**Subject:** Representation Regarding Factual Inaccuracy

I would please like to make the inspectorate aware (acting on behalf of my Client the Turner family of Manor Farm Winterbourne Stoke, who are affected landowners) of a significant factual inaccuracy regarding the information presented at the Hearing and request remedial evaluation.

During the Hearing the Inspectors were shown: FIGURE 10.5 GROUNDWATER SOURCE PROTECTION ZONES, GROUNDWATER ABSTRACTIONS AND RIVERS WITHIN THE GEOLOGY AND SOILS STUDY AREA. The representative of Highways England used the plan to show those groundwater receptors (abstractions) that are positioned in close proximity to the proposed alignment.

Drawing file: published-documents / TR010025-000331-6-2_ES-Figure_11.4_GroundwaterAbstractions_SPZ.pdf

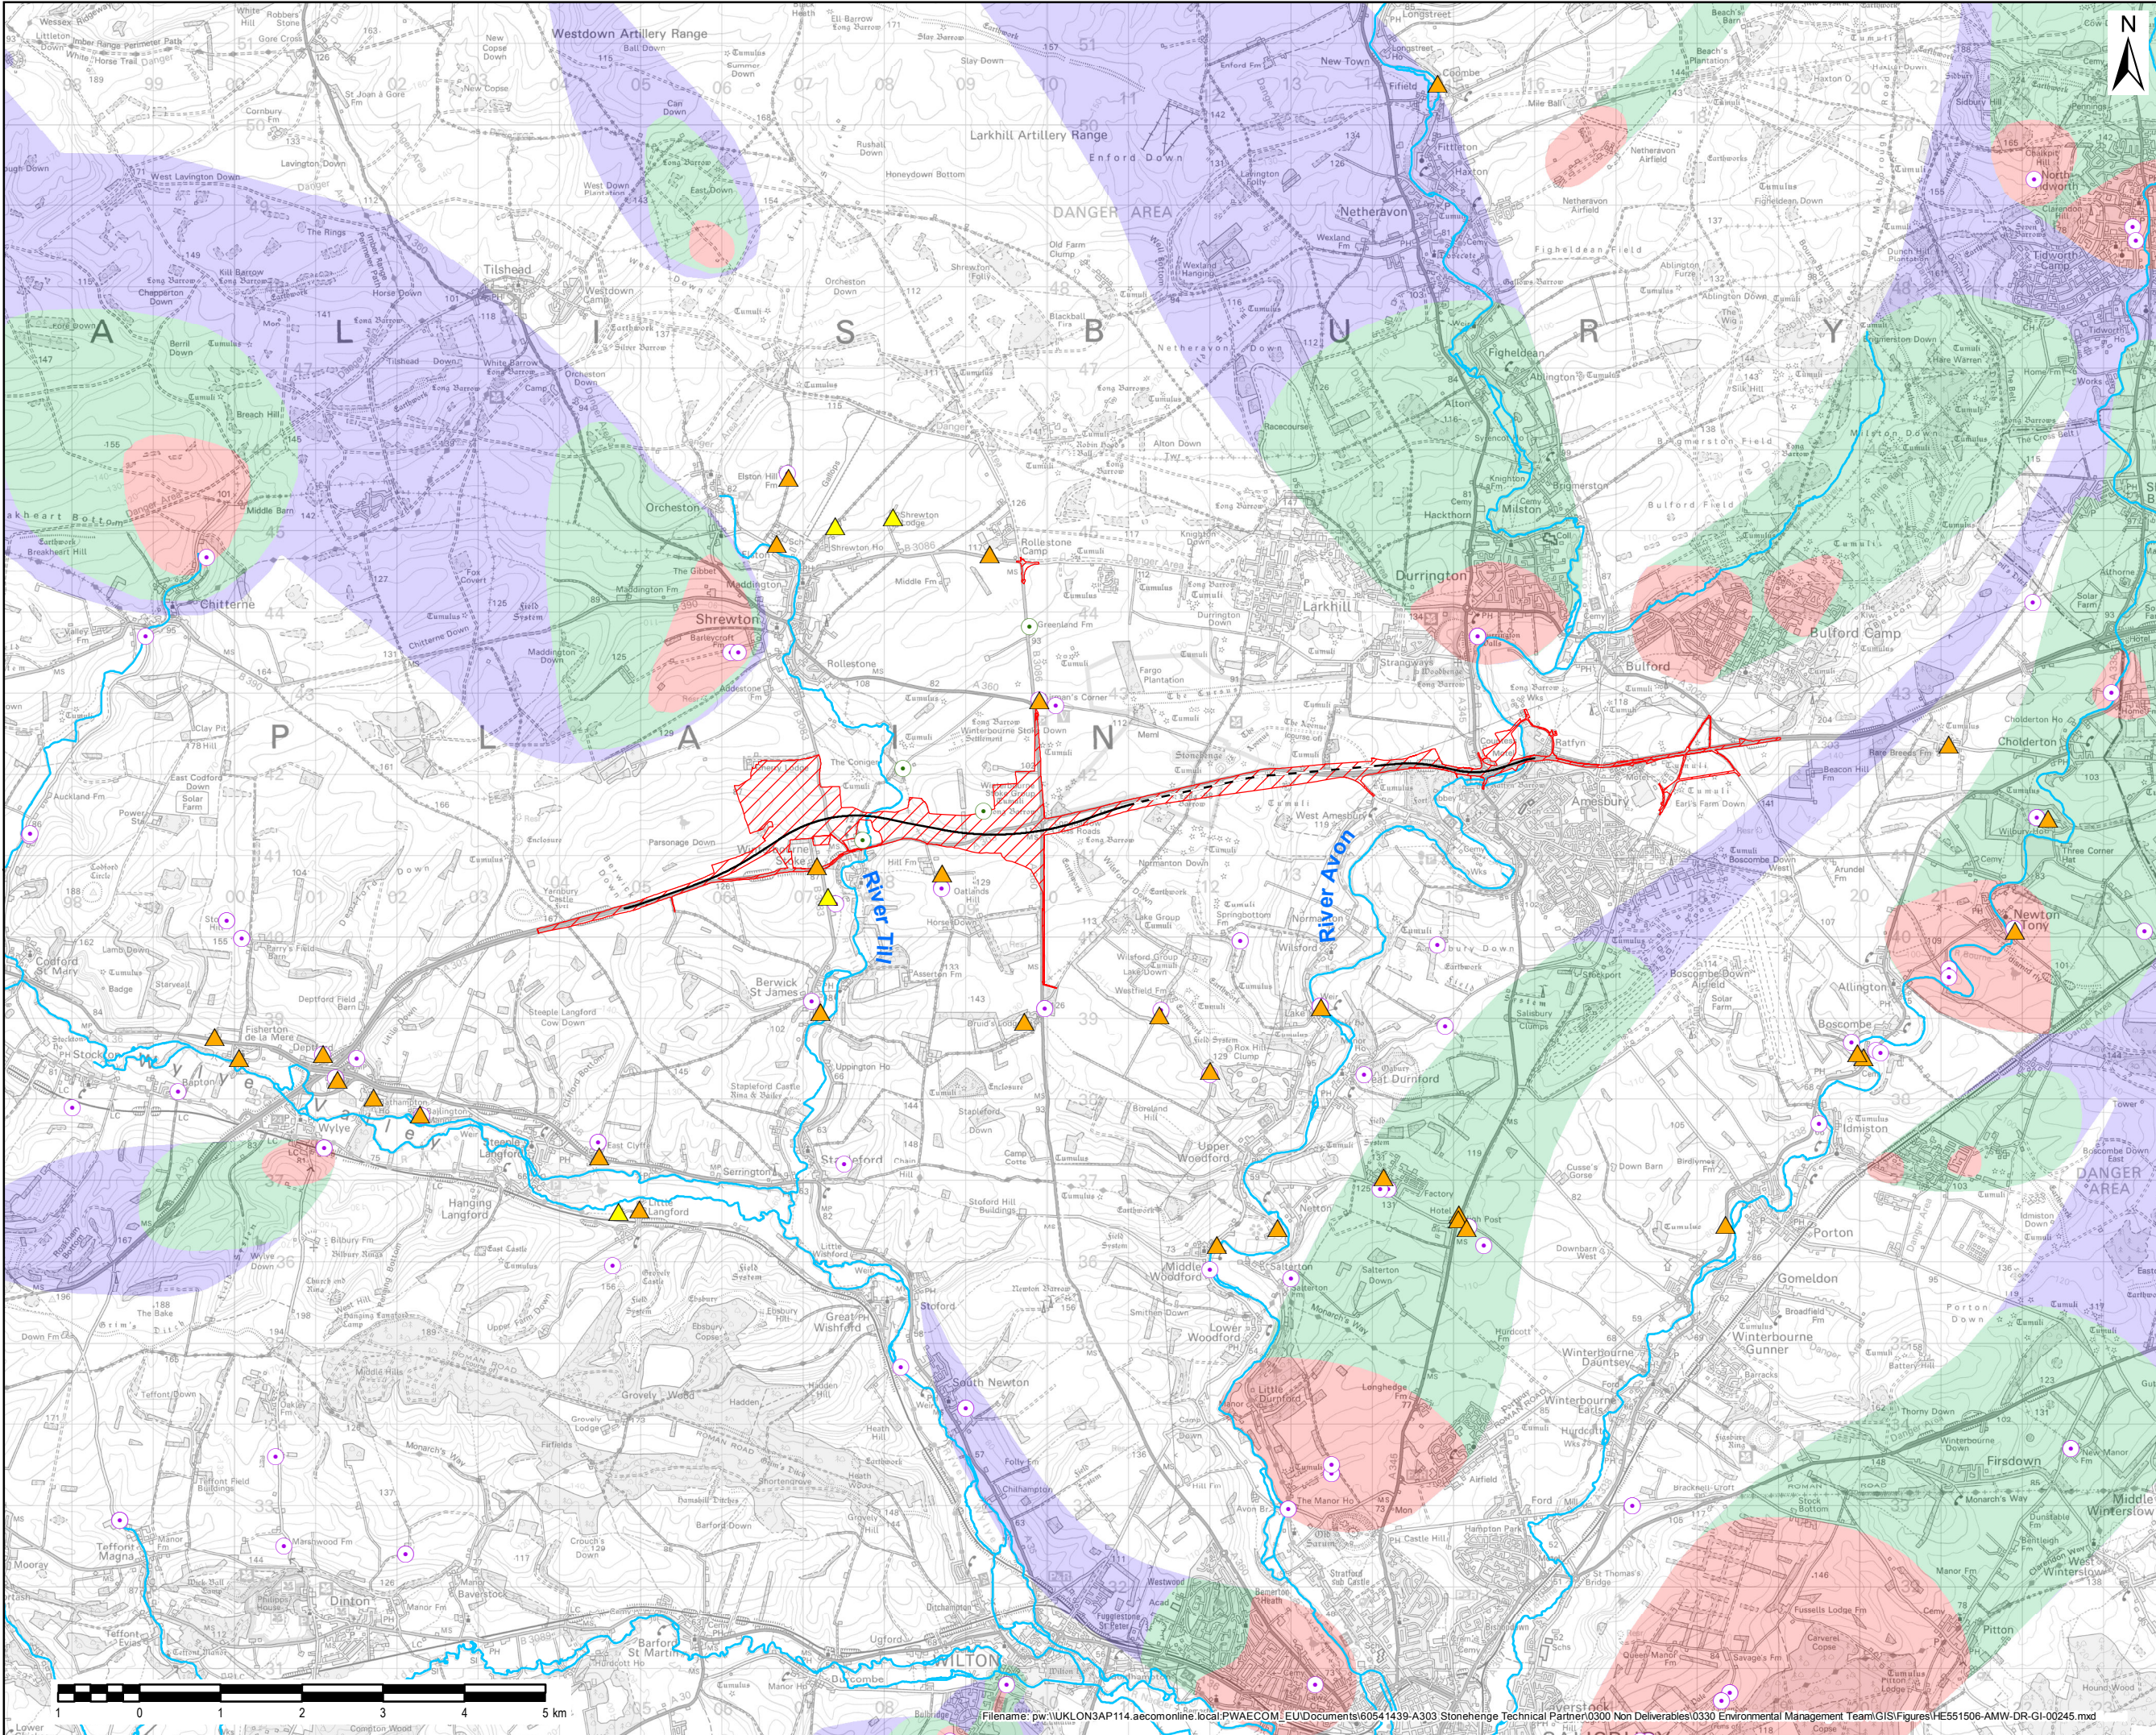
My client does in fact have a licenced abstraction that is not marked on the Fig 10.5. Highways England was made aware of this missing information through response to consultation dated 19<sup>th</sup> April 2018. Copies of the abstraction licences were subsequently sent to Highways England. We were then informed accordingly that the Environmental Statement was updated and an explanation given as to why this abstraction was not assessed in the first instance. This confirmation was provided in the Consultee record of Engagement ID: SH230418-10. I paste below the relevant extract.

Water abstraction, particularly point CL021 (see appendix of response document)	Water Abstraction	Environment	<p><u>Issue</u></p> <p>The PEIR has not taken account of water abstraction from Manor Farm.</p> <p>Therefore there are a further five points of abstraction in close proximity to the proposed works which are receptors risks for contamination.</p>	<p>We can confirm that the project team received a plan from the Turner which confirmed the location of four of the boreholes. These boreholes have been included within the ES, including an explanation of why they were missed in the PEIR. A 50m exclusion zone will be applied the boreholes where they sit wholly or partially within the DCO boundary.</p>
---	-------------------	-------------	---	---

It appears that despite the fact that many conversations have been held with Highways England regarding these boreholes and a copy of the licence has been provided (and visits to set up monitoring). The Environmental Statement only references the pre-existing licence and not the current and renewed abstraction. Crucially it also does not show these abstraction points on Fig: 10.5 (the main abstraction point being located immediately adjacent to the route alignment and proposed compound).

We ask the Planning Inspectorate to require the applicant to acknowledge this consented abstraction and to update their documentation.

At approximately 12:43 am this morning the Applicants representative, summarised that Highways England had properly evaluated all receptors and concluded that none were in areas of risk. We would ask that the Planning Inspectorate require that this exercise be reassessed, as it appears that a crucial point of abstraction in proximity to the engineering works has been overlooked.

I apologise that you had to notify us that boreholes were missed off the preliminary environmental impact review in the hearings for the Turners land. I have investigated the matter further, and it appears that 4 boreholes are given in the groundwater risk assessment in Table 3.3 Appendix 11.4 [APP-282]. The table also acknowledged that their licences had expired and were being re-applied for.

The table contains points A-D, but is missing point E (near to point D and approximately 200m south west). I have been assured that none of these points are predicted to be impacted by the scheme, where a falling water table may risk the water supply. Aside from point E, if anything else has been missed, please can you let us have the details as soon as possible?

Again I apologise that point E was missed, and this will be rectified. However, if there are any further details for other boreholes or indeed any other information that we need to be made aware of in relation to the Turner land please can you let us know as soon as possible.
